## City of Ryde Submission Goodman Project Apollo Data Centre Macquarie Park

**SSD-74069708**

**Submission Date: 11 April 2025  
COR2024/131/1**

4 & 6-10 TALAVERA RD, MACQUARIE PARK NSW - VISUAL ASSESSMENT
VP1 : (PHOTO 3535) LOOKING SOUTH-WEST, FONTENOY ROAD | PHOTOMONTAGE

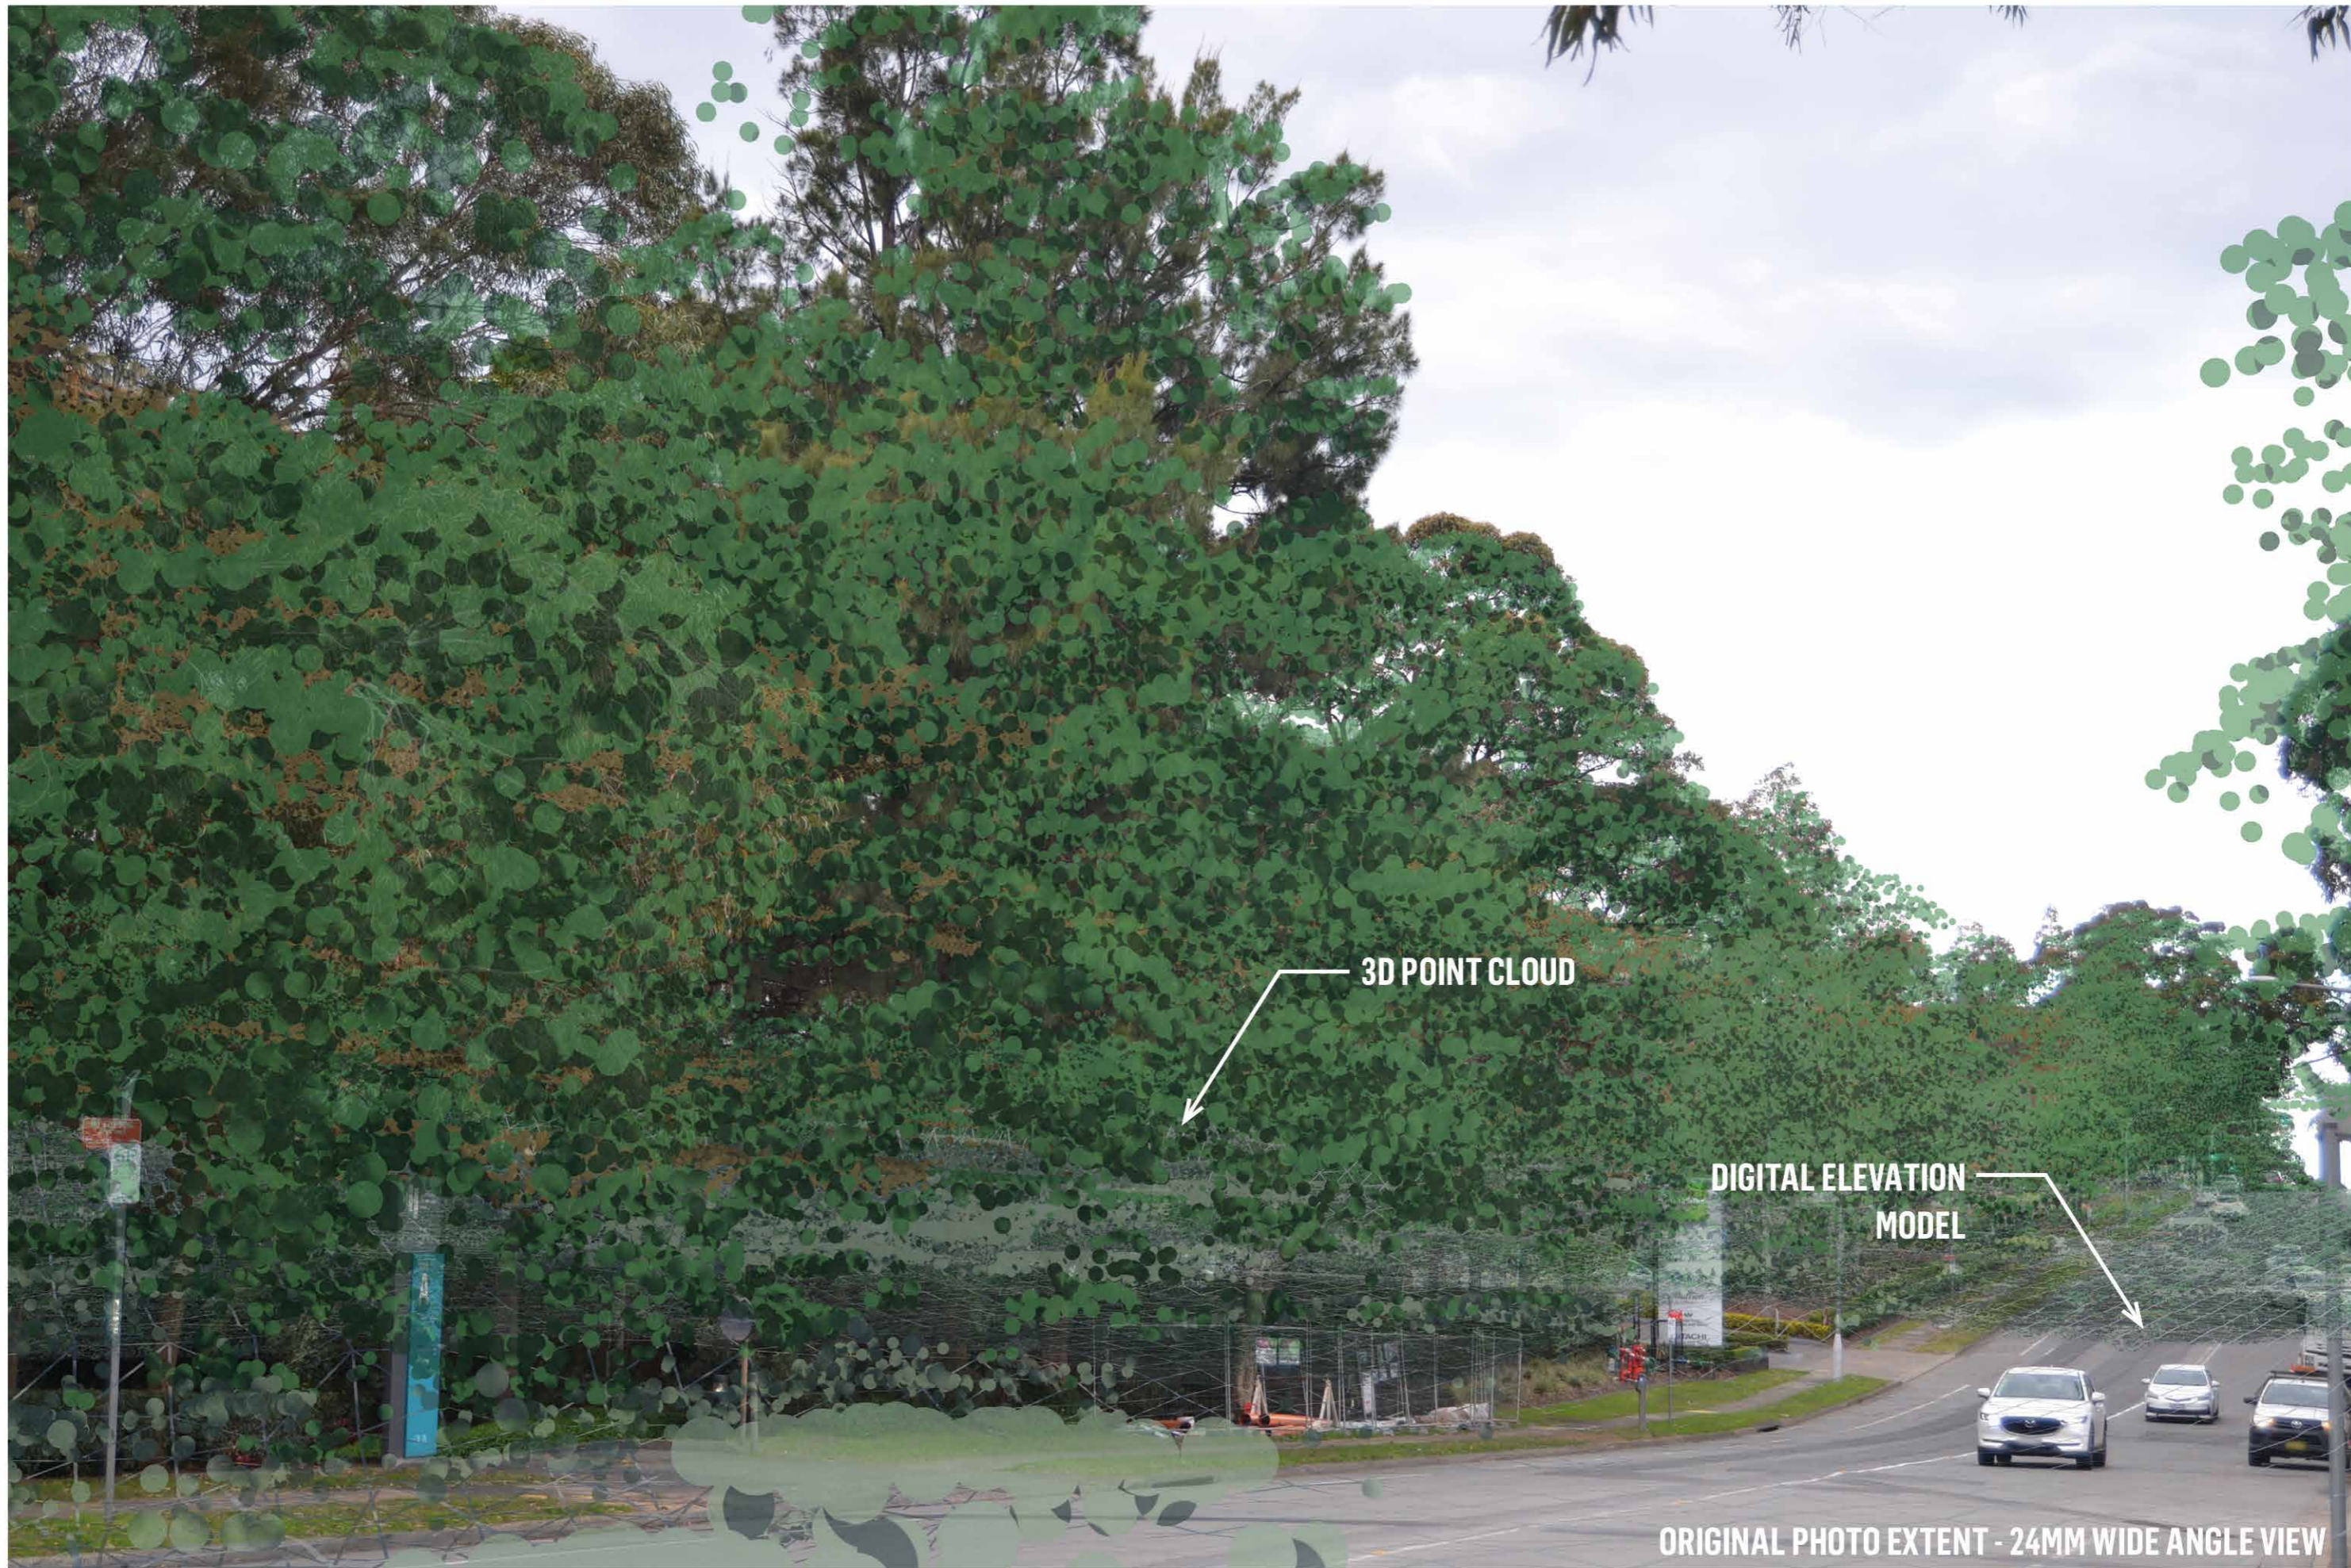
At the above perspective, the building comprises large expanses of blank walls with limited articulation or visual interest. Consideration should be given to integrating public art, additional articulation or even vertical gardens on this prominent corner. Further, the view from residential properties on Fontenoy Road and from the M2 is of large expanses of blank walls, see below:

- Public Art/ Mural could be explored on the façade facing Fontenoy Road providing a unique piece demonstrating a connection to Country.
- Country outcomes could be better achieved by designing with country on the facade of the building facing Talavera. This is particularly beneficial given the frontage will be visible from the +100,000 trips heading north daily which could design via mural to reflect Dharug / Wallumedugal clan symbolism. This design will reduce the heat and radiation from the design whilst improving the aesthetic of the huge footprint. It can connect into the Grandmother tree placement and combined with signage has opportunity to offset the bulk, scale and overpowering design in the prominent location.

4 & 6-10 TALAVERA RD, MACQUARIE PARK NSW - VISUAL ASSESSMENT
VP3 : (PHOTO 3659) LOOKING WSW, LANE COVE ROAD | PHOTOMONTAGE

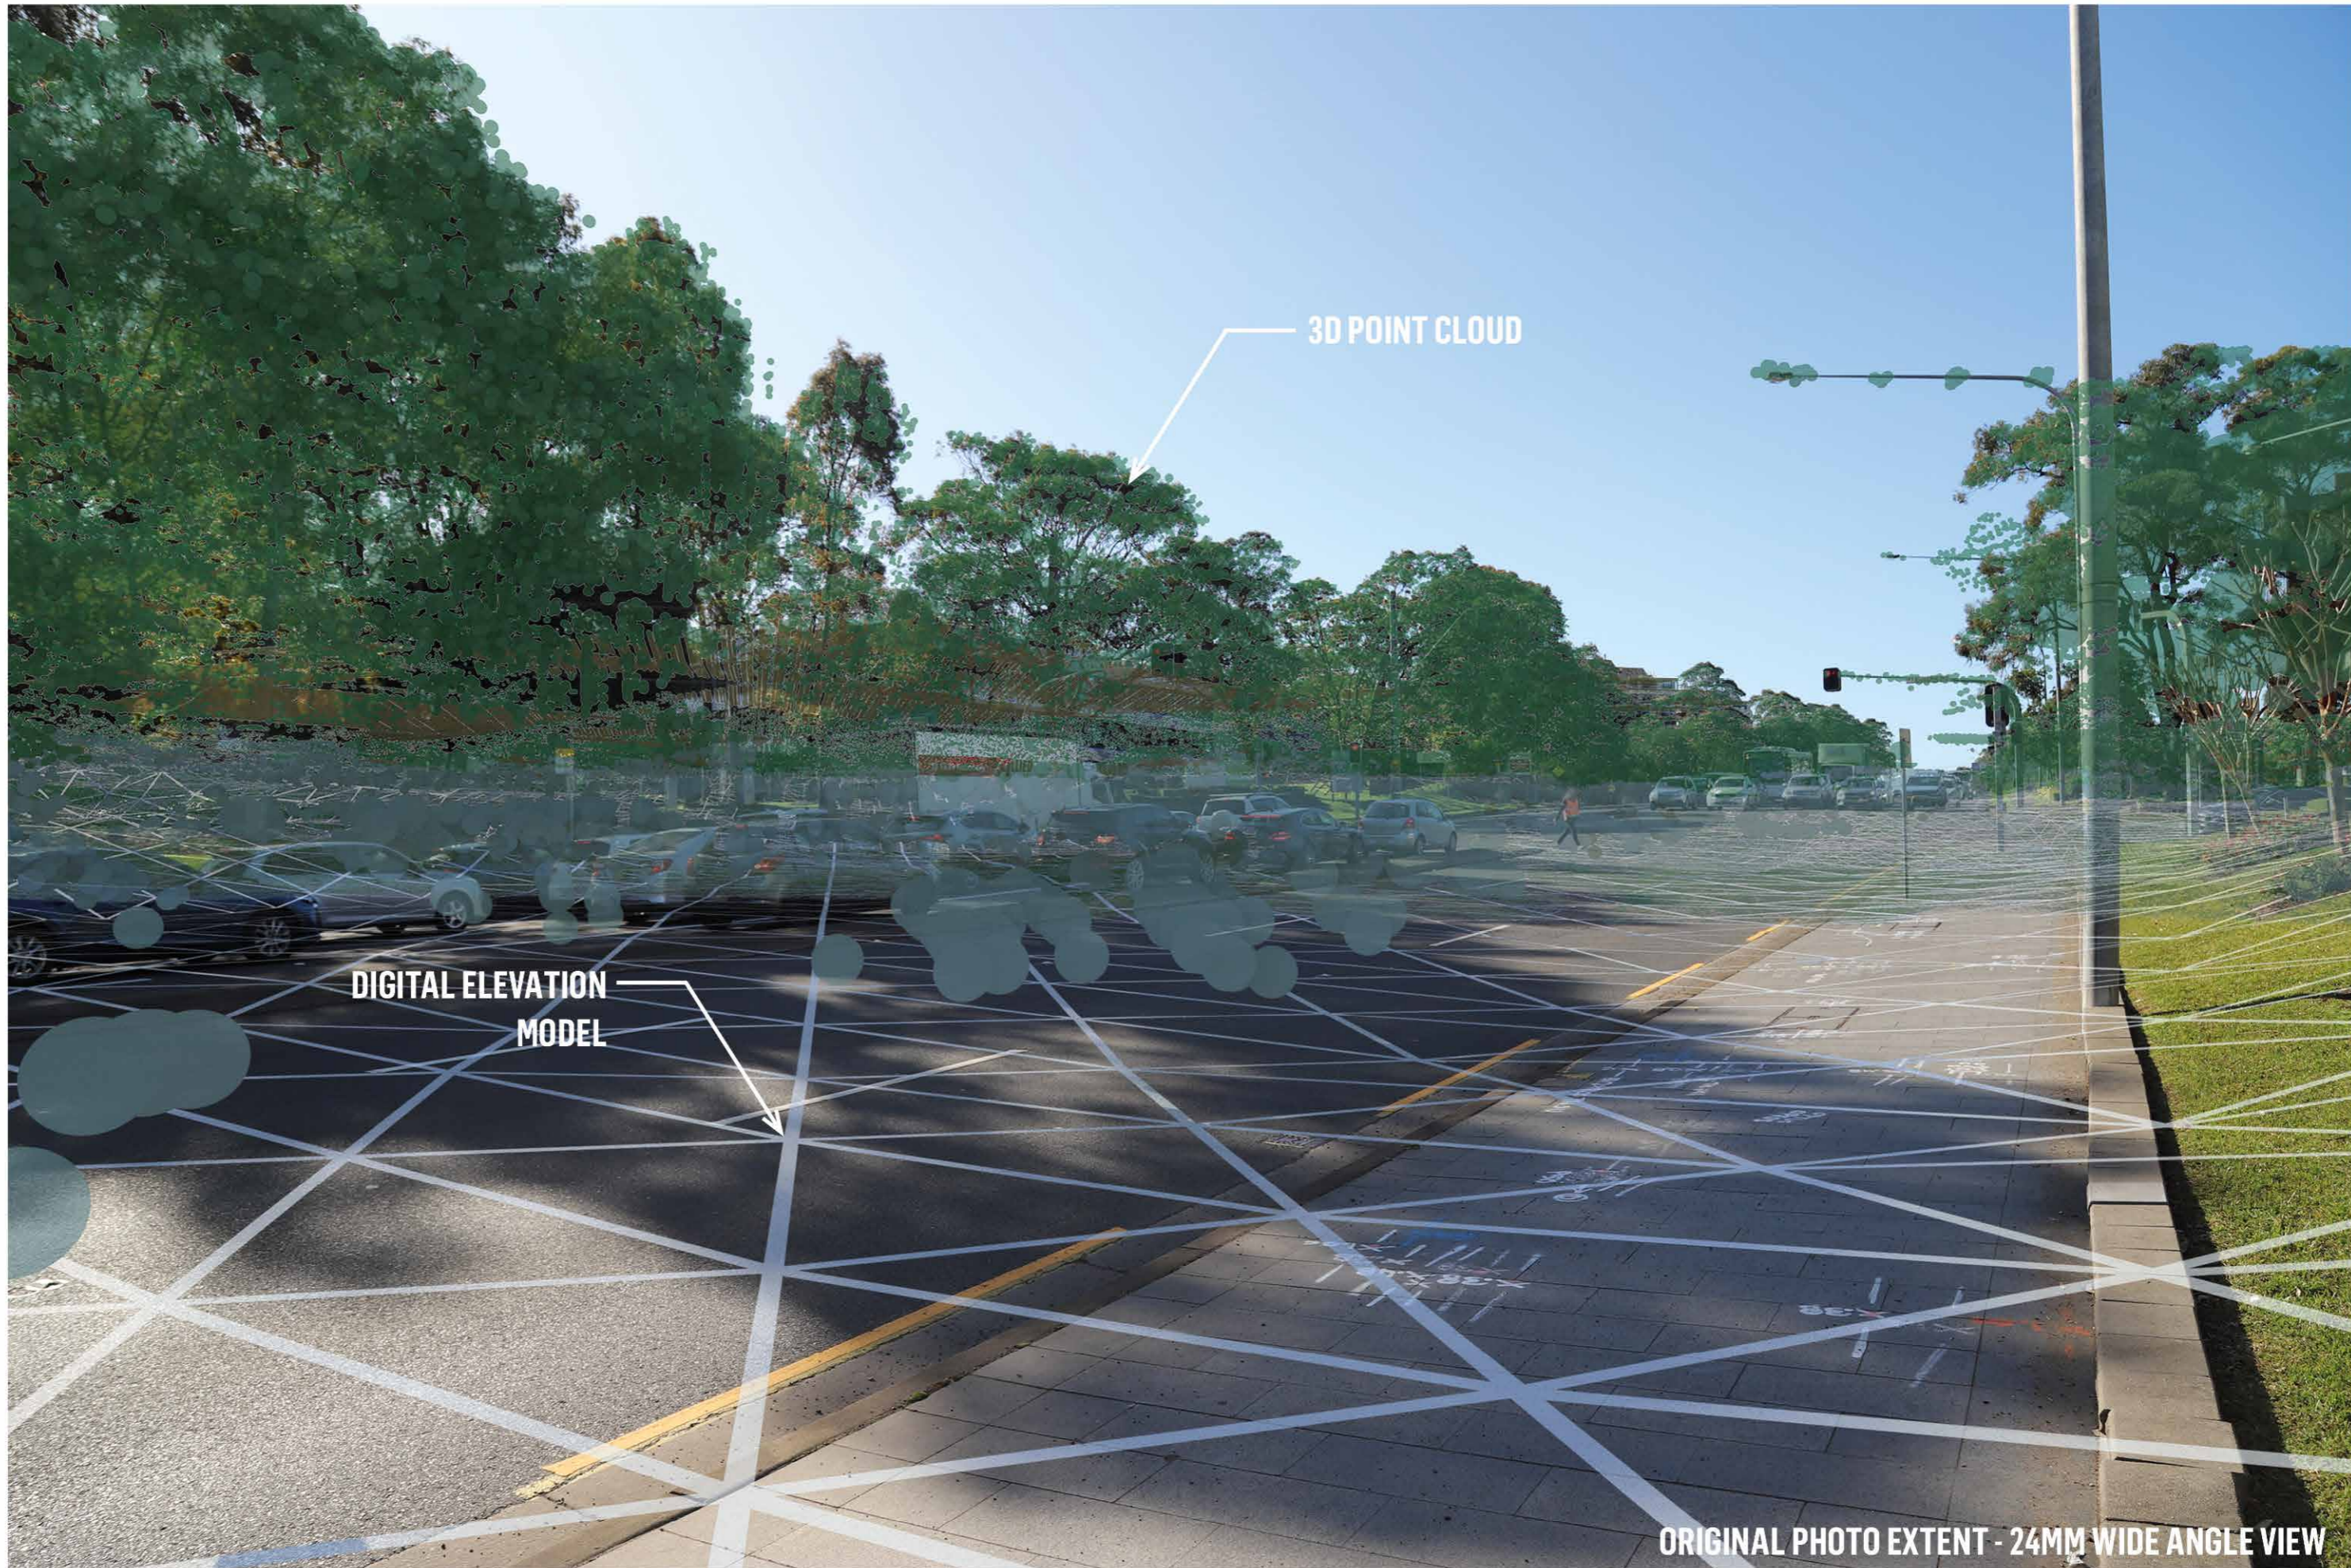
Concern is raised in relation to the presentation of the building from the corner of Lane Cove Road and the M2 as depicted in the figure below:

To alleviate the developments visual impact as a result of its bulk and scale the following items are recommended to be considered:

- Leverage the scale and visibility of the proposed building from Lane Cove Road north to provide large scale public artwork, signalling entry point to Macquarie Park.

- Council notes that Public Art is required by both the Macquarie Park DCP and the Macquarie Park Urban Design Guide.
- Explore additional articulation of the building face to offset building bulk.
